Subject: RE: Planning Consultation on: FG/74/20/DOC

Engineers Comments Regarding Surface Water Drainage

Application No: FG/74/20/DOC

Site Address: 40 Little Paddocks Ferring BN12 5NJ

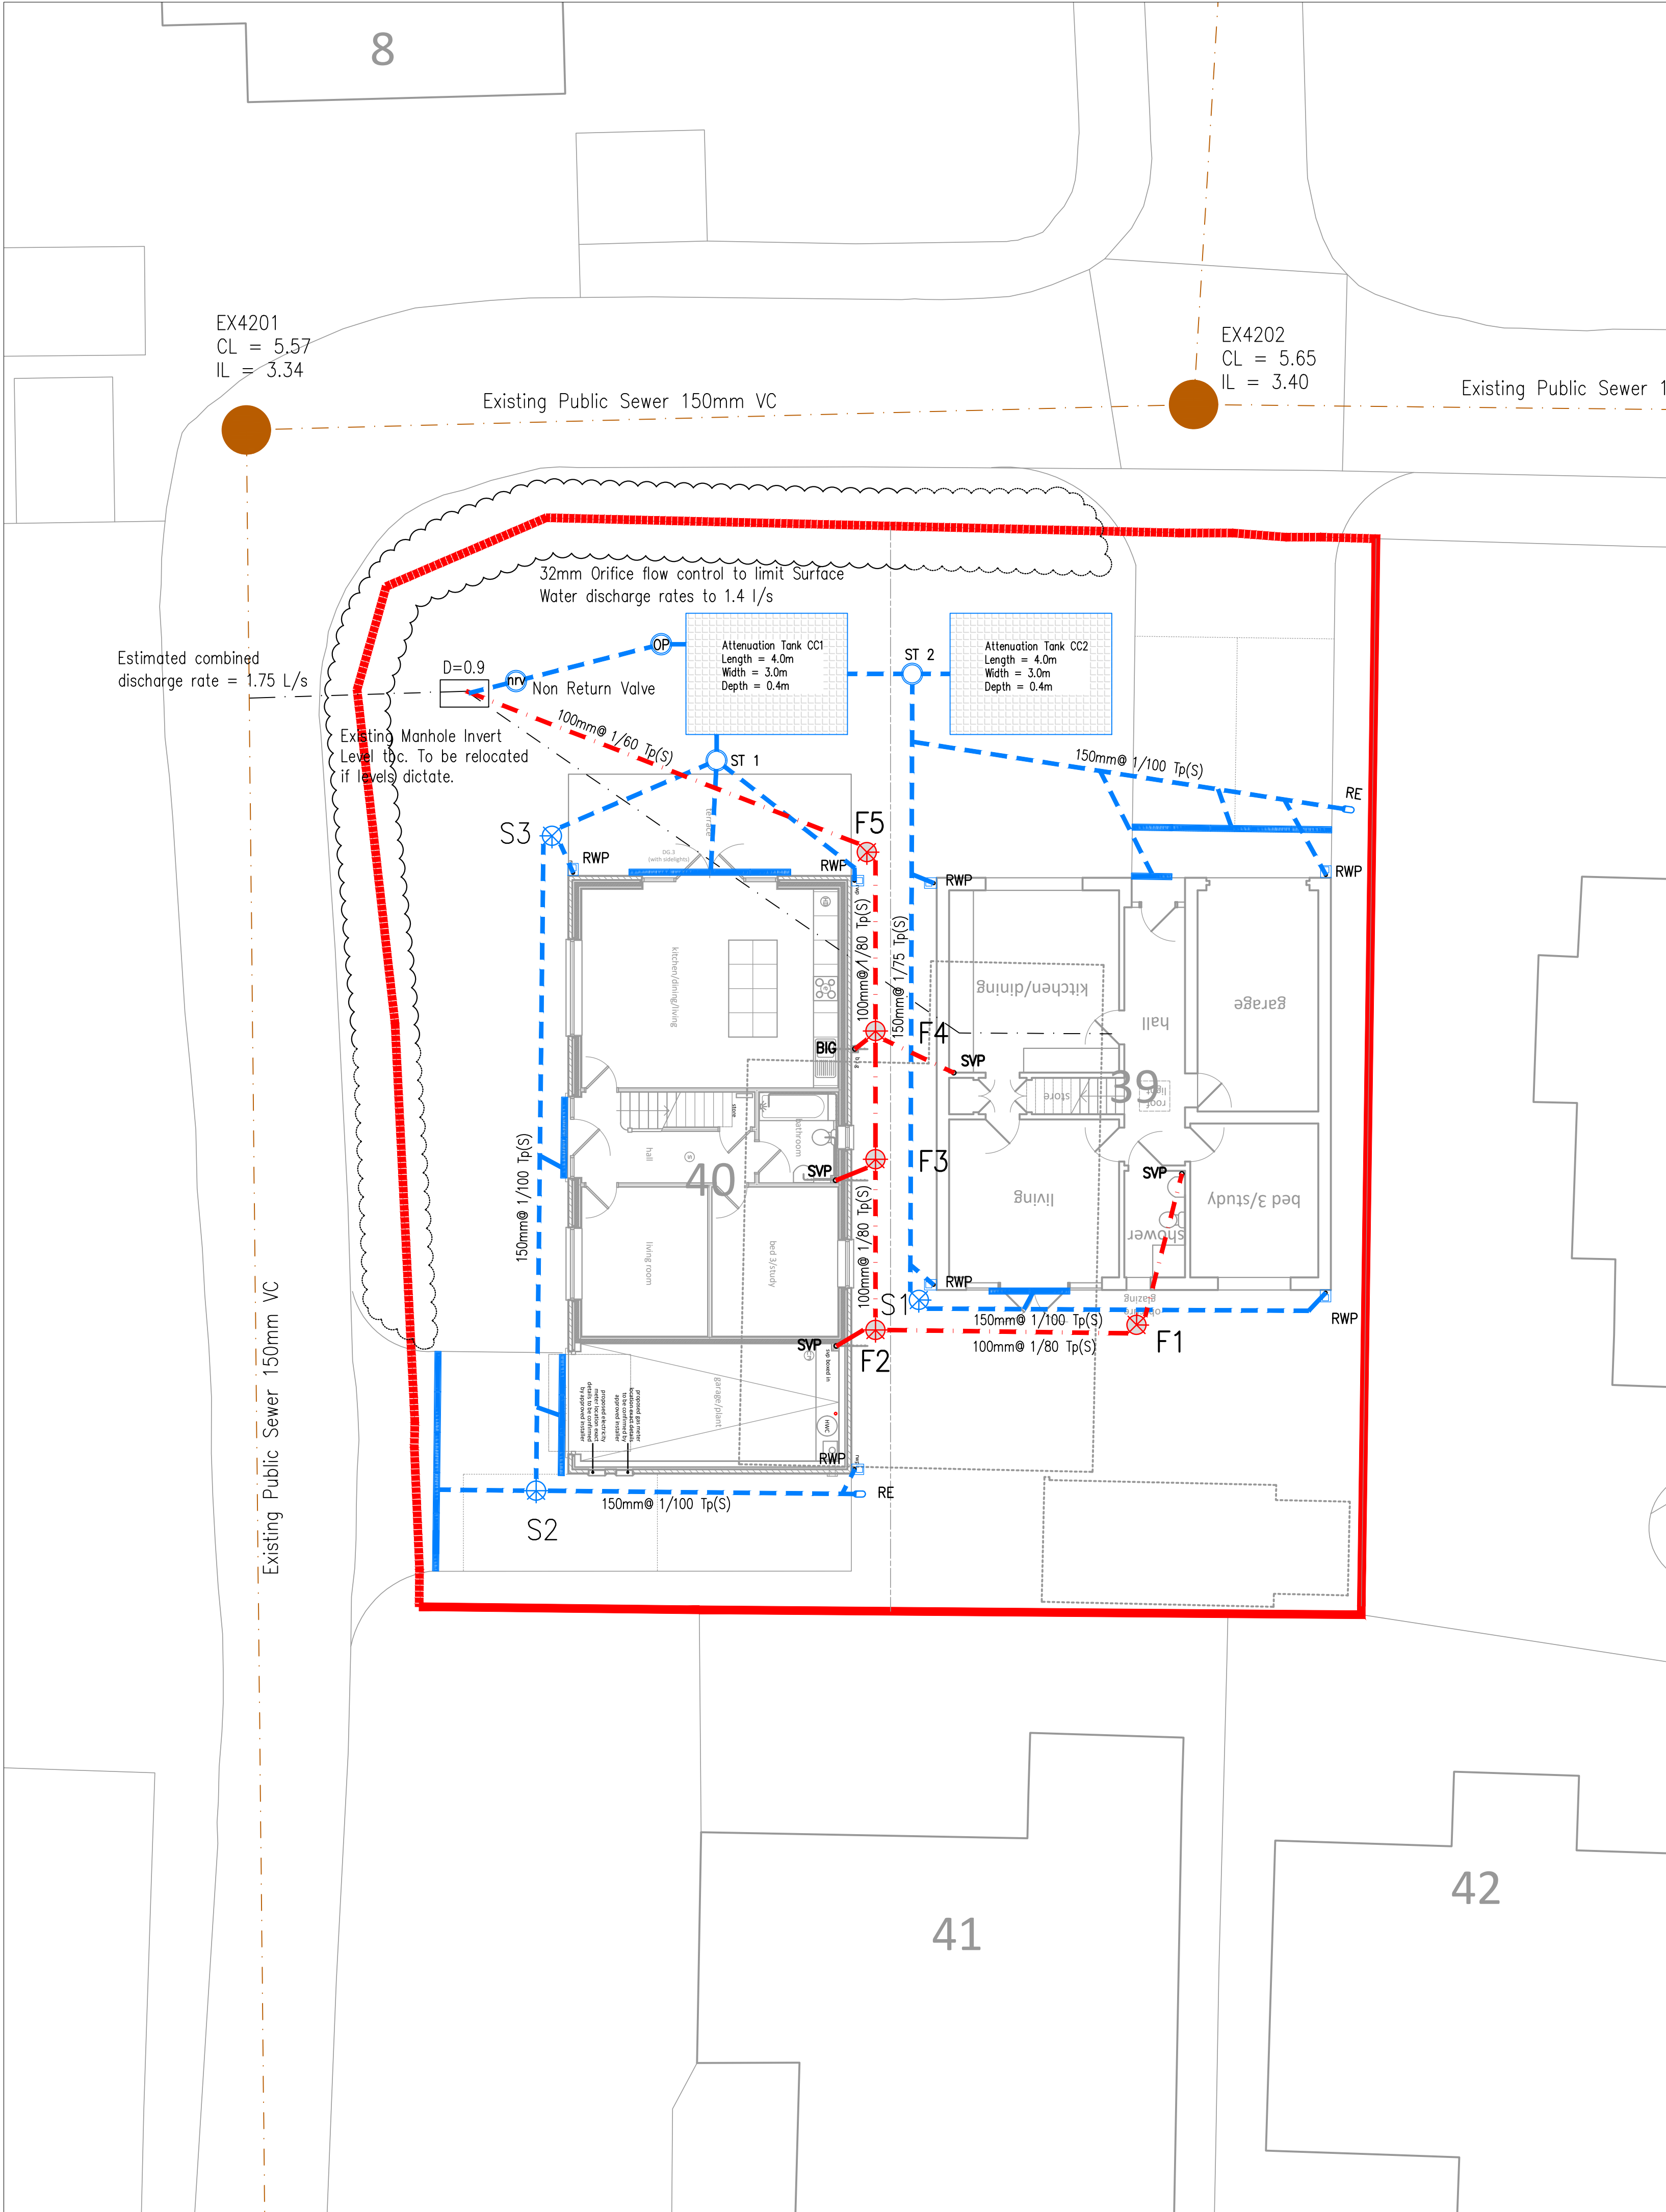
According to our records there are no watercourses or surface water sewers in the vicinity of the site. This means that surface water will likely have to be drained to the foul sewer. We will need to see agreement to this from Southern Water. In addition a capacity check (from Southern Water) will be required to determine the allowable discharge rate from the site. This will need to be submitted to ADC in order to discharge this condition.

Before recommending discharge of condition 3, the following details will need to be submitted:

1. A detailed drainage layout. This should include:
 - a. Pipes: diameters, material type, gradients/falls, invert and cover levels
 - b. Manholes/inspection chambers, silt traps: Cover types, invert and cover levels. (A silt trap must be provided upstream of an attenuating structure.)

- c. Control structures (if necessary): As b. plus the restricted flow rate and design head.
- d. Attenuation features: Dimensions, invert and cover levels.
2. Calculations to show the volume of the attenuation structure required as a result of Southern Water capacity check.
3. Construction detail drawings for all components listed above plus pipe bed and surround.
4. Agreement from Southern Water to the proposal to discharge surface water to the foul.
5. A capacity check from Southern Water showing the allowable discharge rate of surface water to the foul sewer.

Due to the scale of work and detail required, and the anticipated time frame to complete such work, it is recommend that this discharge of conditions application is refused and the applicant re-submits at a later date.
